**SUBJECT**  
**Response to Drainage Planning questions –**  
**Warrender Primary School**

**CLIENT**  
 London Borough of Hillingdon

**DATE**  
 01 February 2017

**OUR REF**  
 35311100 / W / DN003

SITE LOCATION:
**WARRENDER PRIMARY SCHOOL
 OLD HATCH MANOR
 RUISLIP**

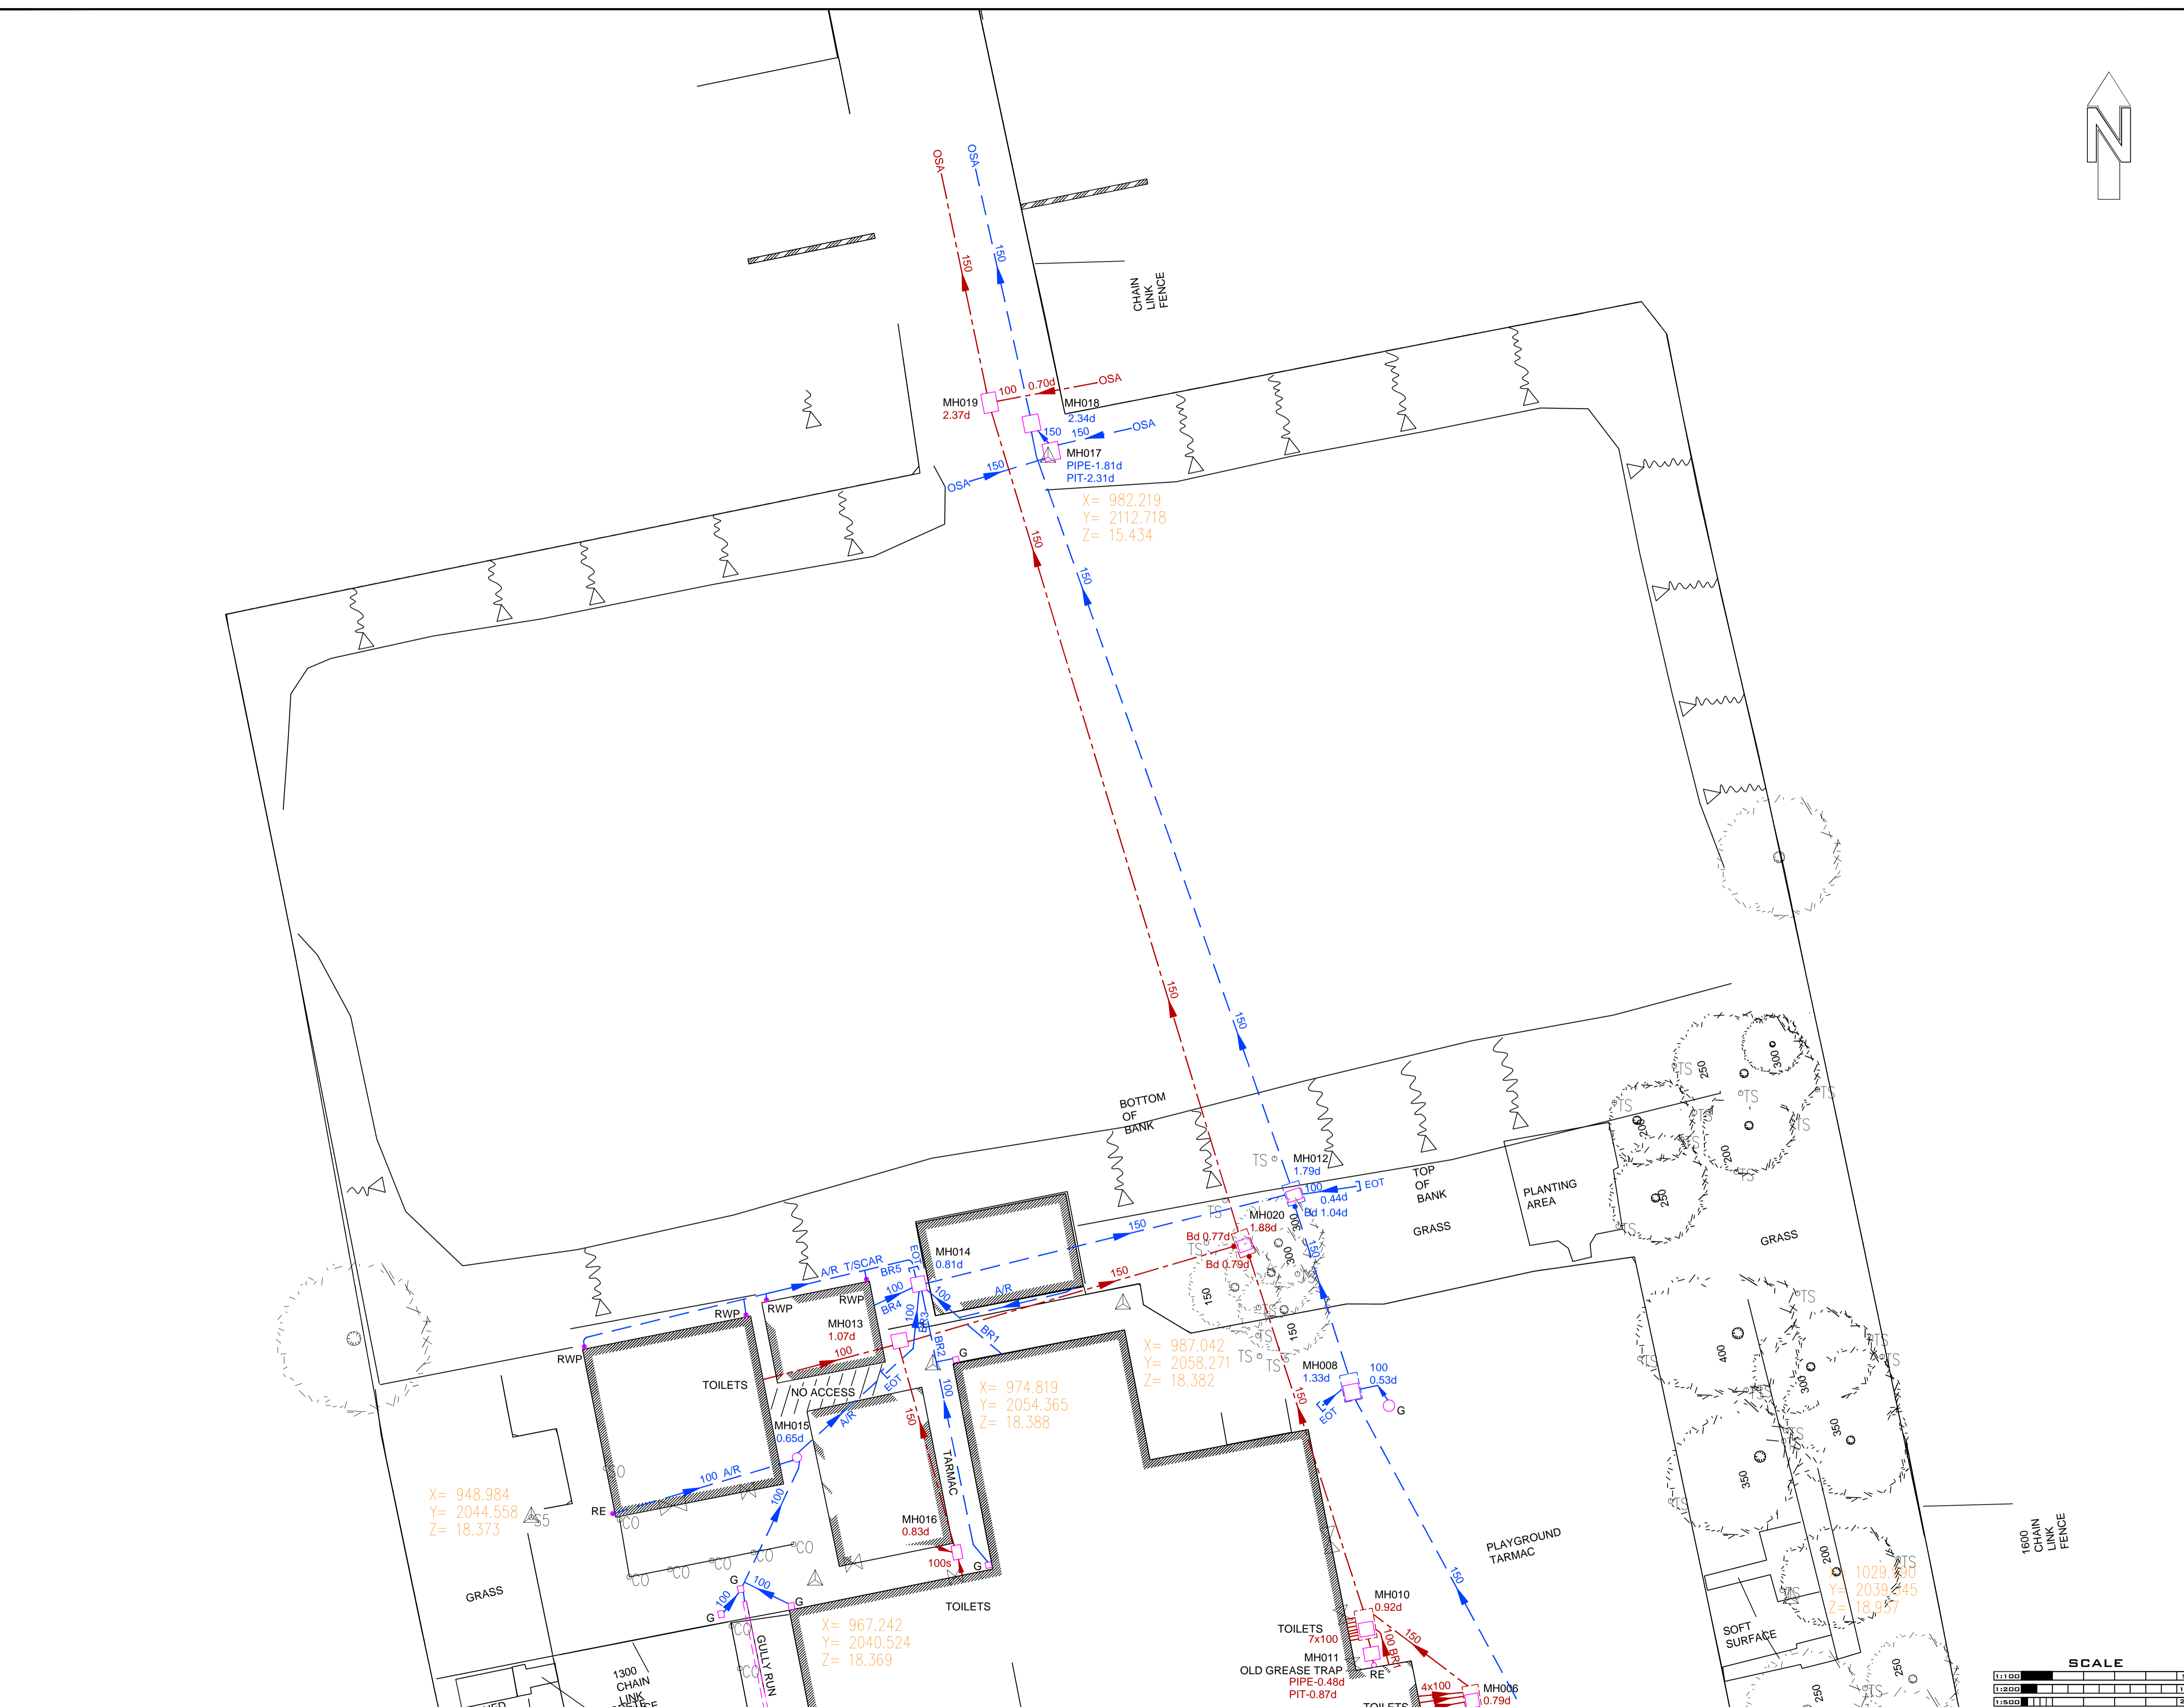
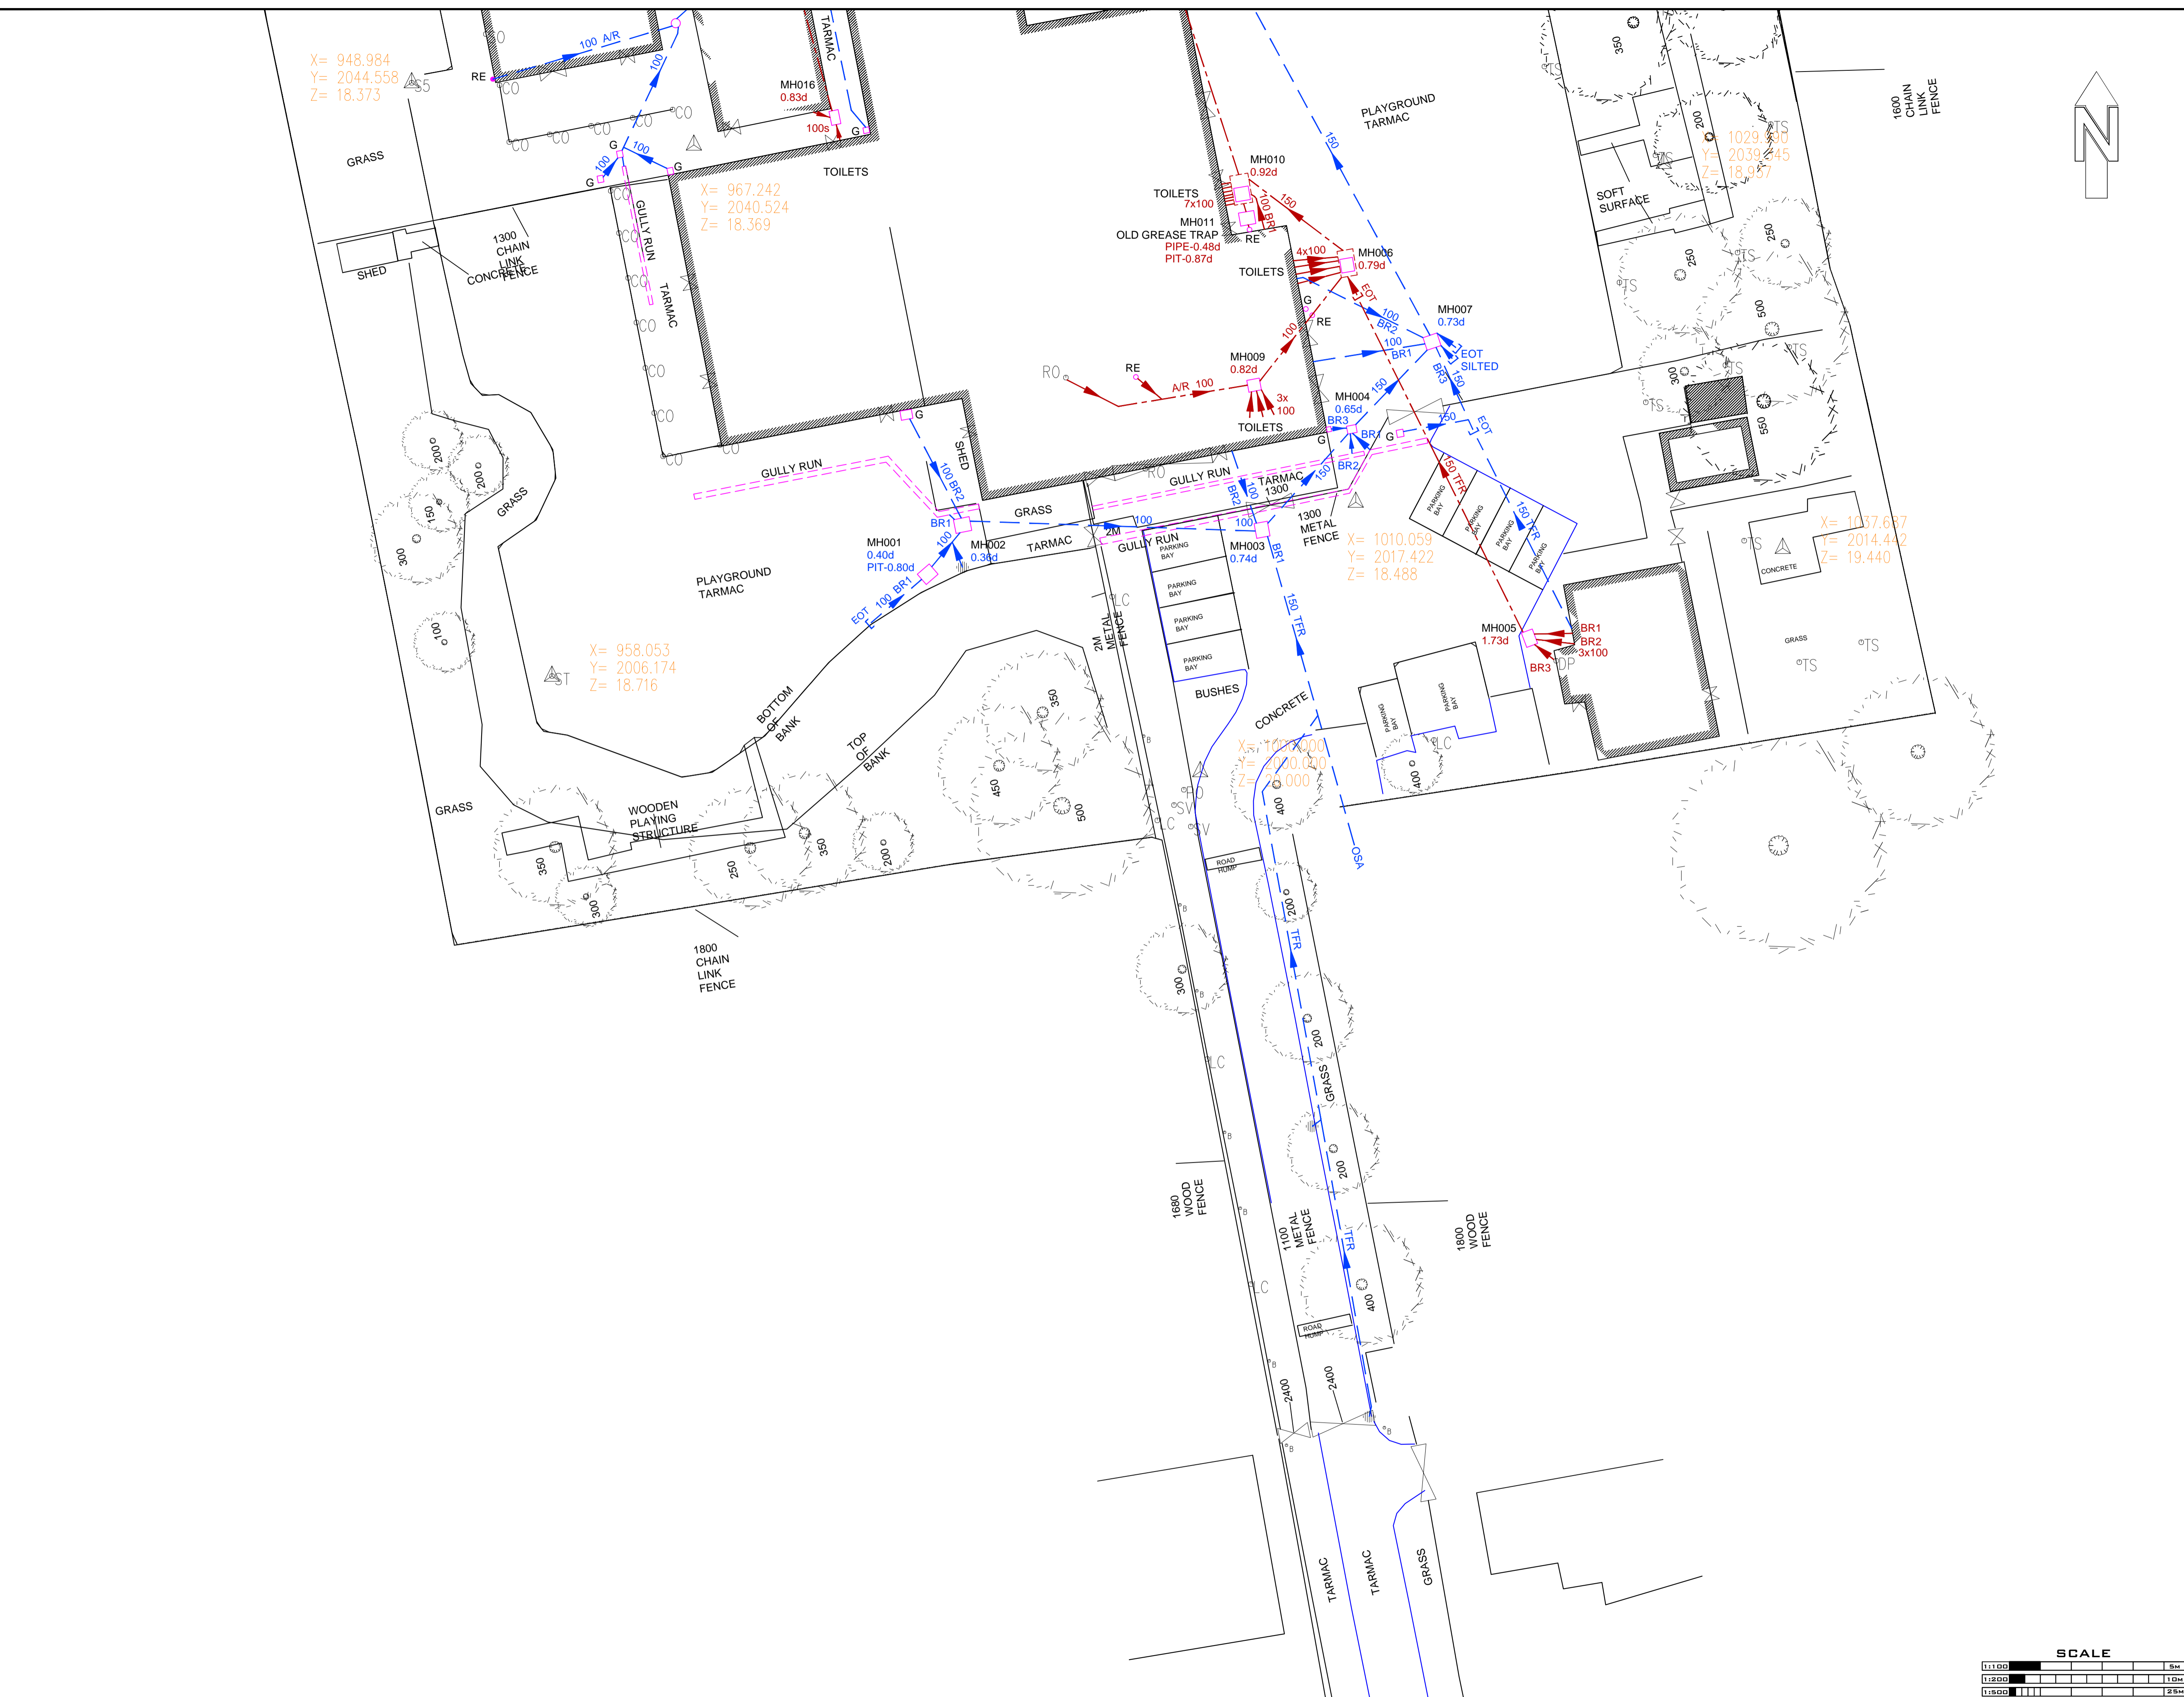
**It is noted that the original FRA now refers in the surface water management section to the variety of site constraints which influence the final drainage design. The additional design note refers to a CCTV survey that has been undertaken but not provided, with this additional information, and should be provided to understand the issues highlighted on site.**

**The proposals for the drainage scheme address the proposed development area. It is noted that a new drainage link is provided so that there is no dependence on the existing and what appear to be broken and inadequate one. However you cannot make the conclusion that it will solve the some of the existing problems as the CCTV is not provided, and it provides limited additional extra capacity.**

Please see attached the CCTV provided.

We have designed the new drainage to accommodate surface water runoff from the new building, new external areas and MUGA. Connection to any existing downstream infrastructure within the site boundary will be upgraded to suit the additional flows from the new development in terms of capacity and operation.
